Application for a non-material amendment following a grant of planning permission.

Demolition of conservatory and construction of two storey extension

Reference number: AW/303/19/HH

A further change of window arrangement on the first floor of the rear elevation (proposed)

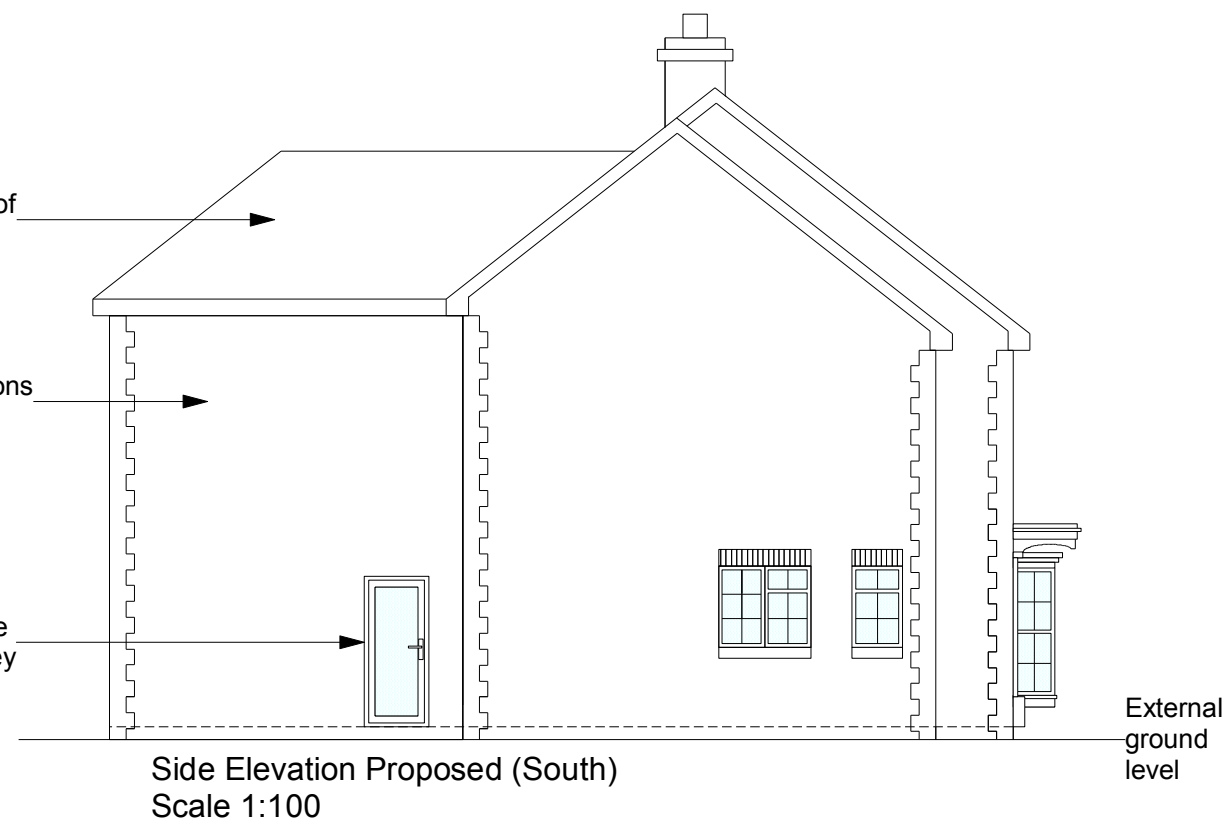
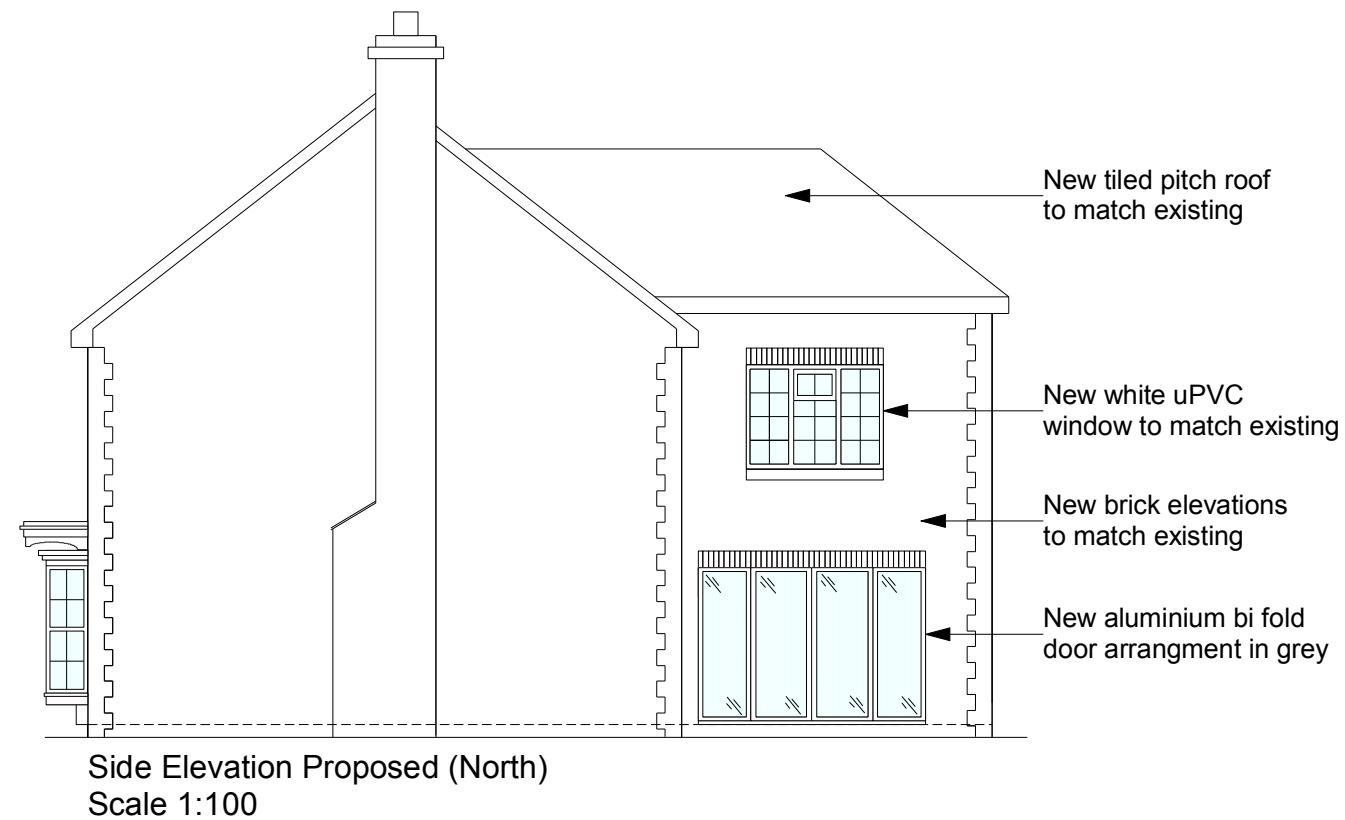
CC003 Rev C & CC004 Rev C

CC003 Rev D & CC004 Rev D

Due to proposed internal room reconfiguration (F,F & E) and to improve natural daylight into the new bedroom.
